Planning Application No: 3/2026/0263

Proposal: Proposed conversion of habitable accommodation to a garage with first floor extension above.

Location: The Warren Warren Fold Hurst Green BB7 9QH

Tahira Akhtar BA (Hons)
Technician
Highway Development Control
Highways & Transport
Lancashire County Council

Drawing Title  
**Proposed Site Plan**

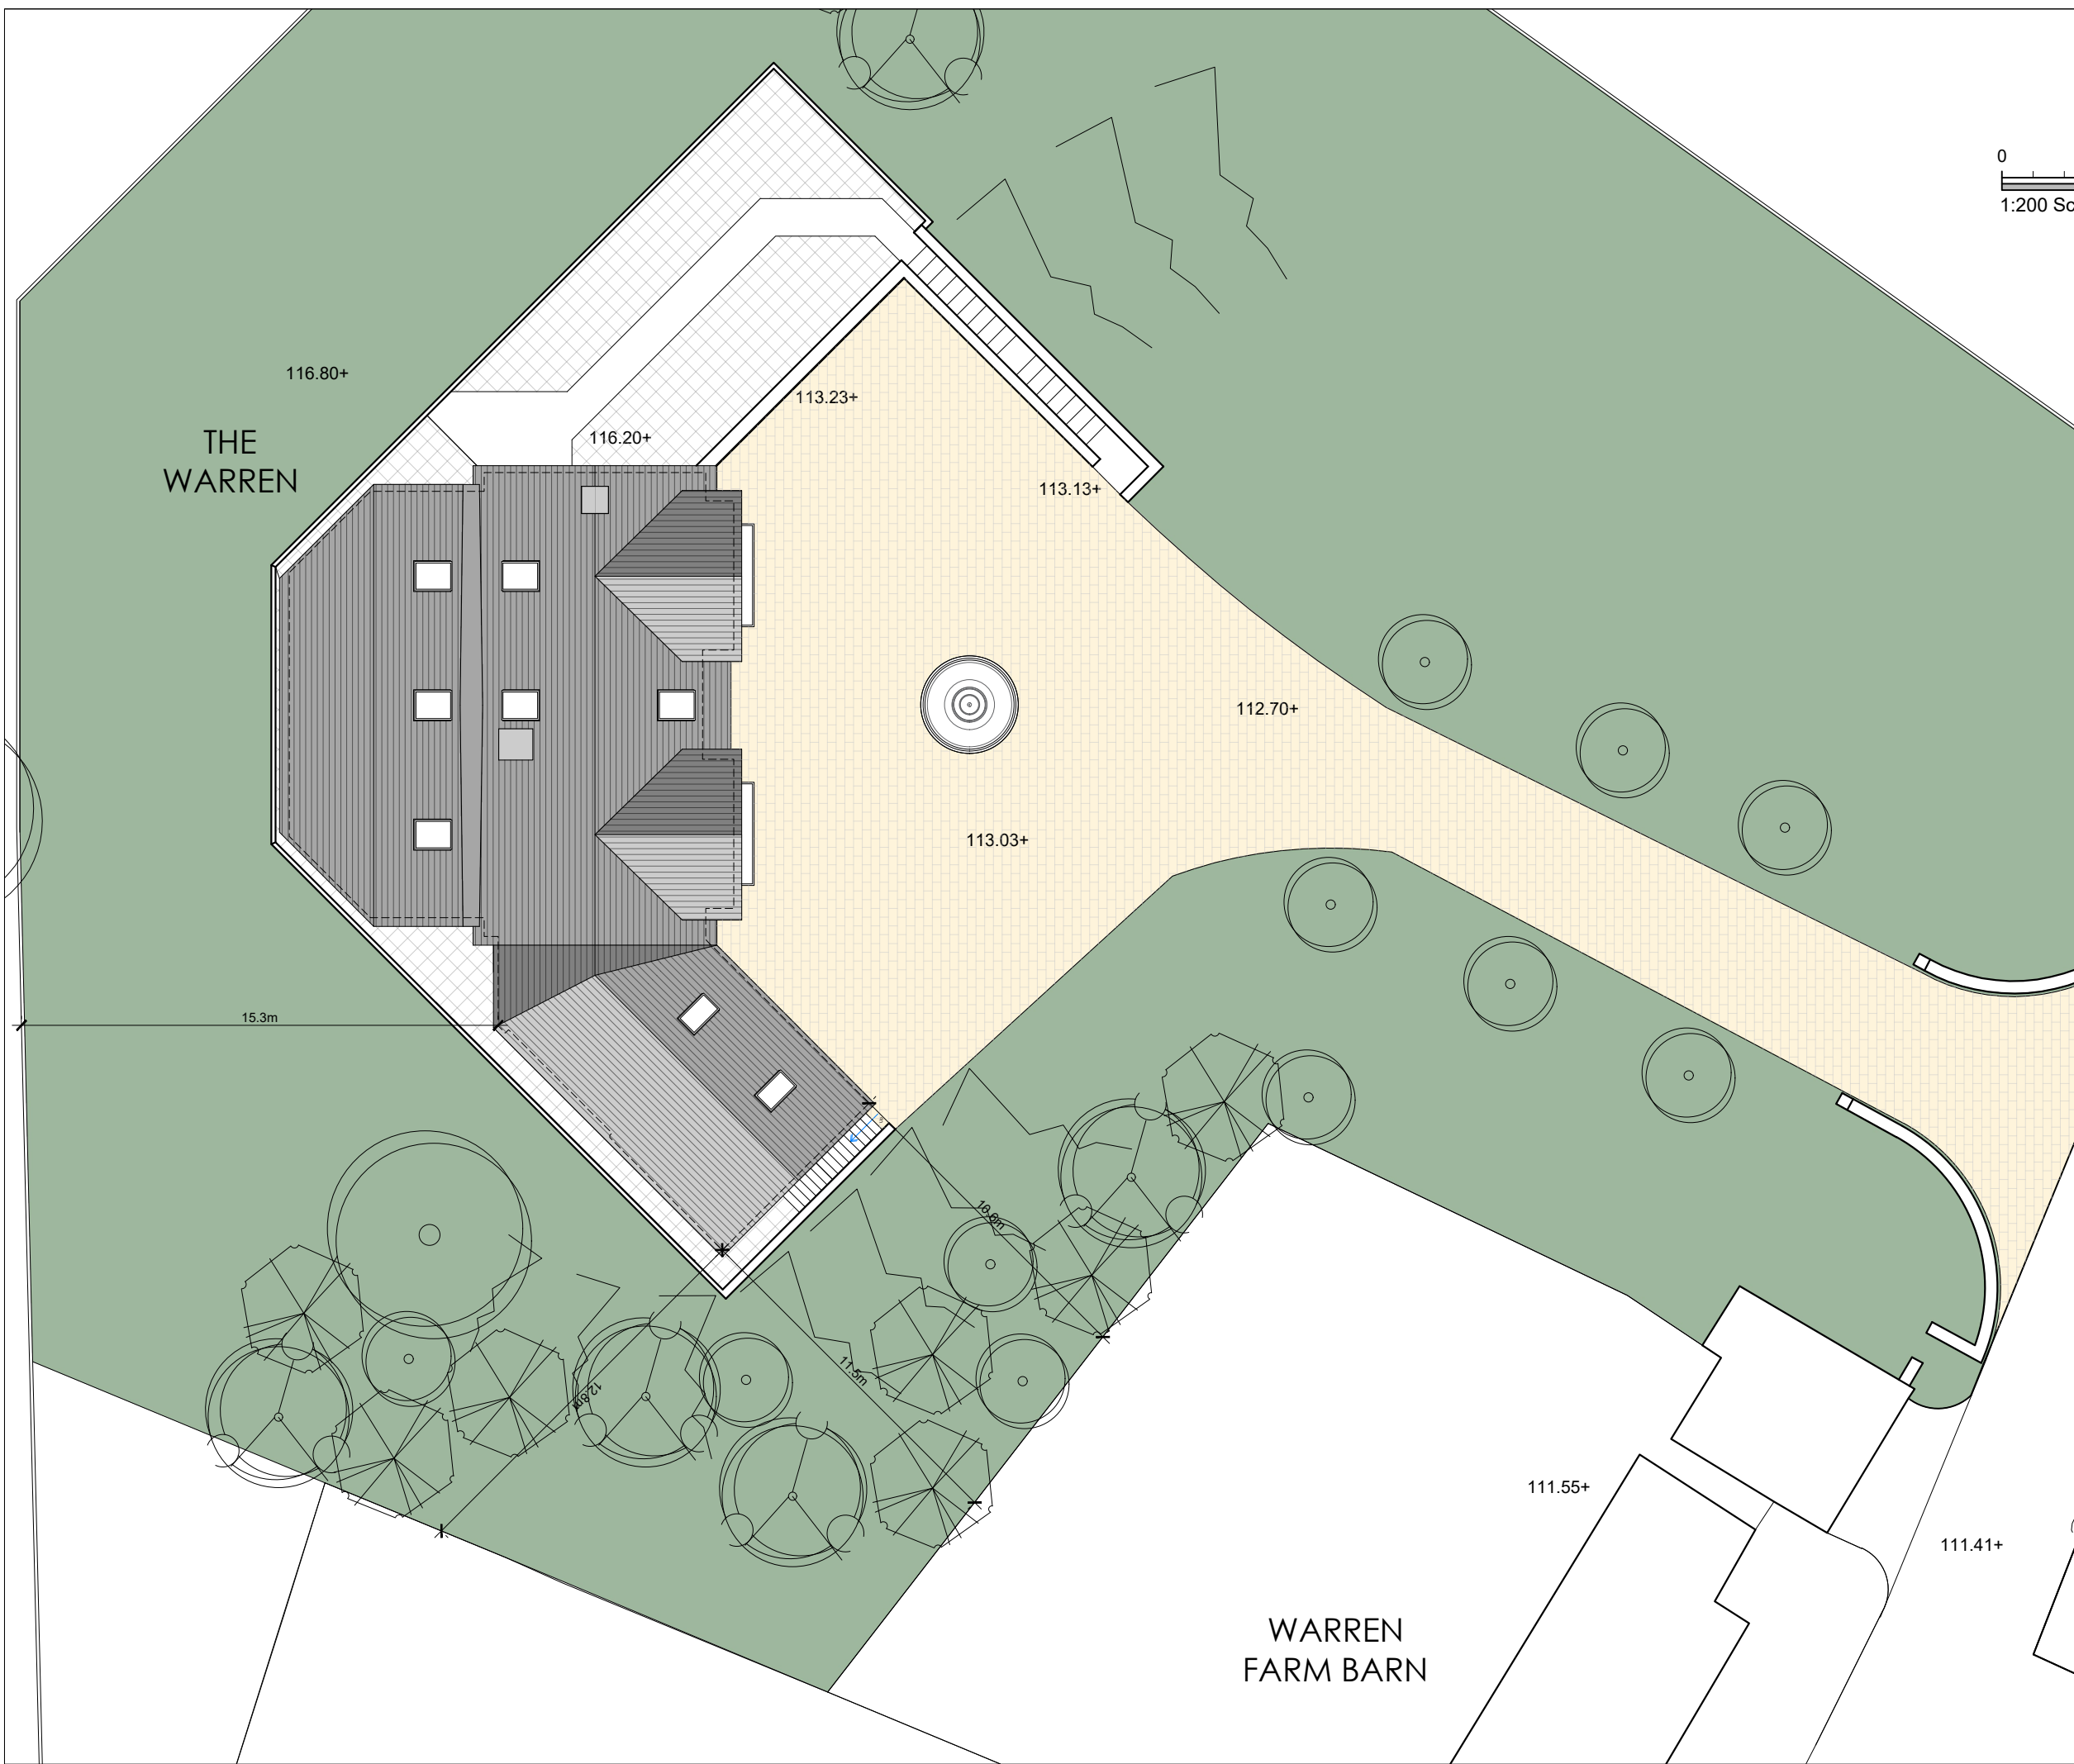
Please note that there is a Public Rights of Way (FP030364) close the application site which must not be obstructed during the proposed development. The granting of planning permission does not constitute the diversion of a Definitive Right of Way.

The proposal does not create an increase in bedrooms. Therefore, no change to the existing parking standards.

The site shall enhance its sustainable transport options to actively encourage and support sustainable transport use. The development must include covered and secure cycle storage to promote cycling as a sustainable mode of transport.

In addition, the development is expected to incorporate an electric vehicle (EV) charging point to further encourage sustainable travel choices. In line with Department for Transport (DfT) guidance on Electric Vehicle Charging in Residential and Non-Residential Buildings, charge points must deliver a minimum power output of 7 kW and be equipped with a universal socket capable of charging all types of electric vehicles.

1. The garage hereby approved shall be kept available for the parking of vehicles ancillary to the enjoyment of the household and shall not be used for any use that would preclude the ability of their use for the parking of private motor vehicles, whether or not permitted by the provisions of the Town and Country Planning (General Permitted Development) Order 2015 or any order amending or revoking and re-enacting that order.
Reason: To ensure that adequate parking provision is retained on site.
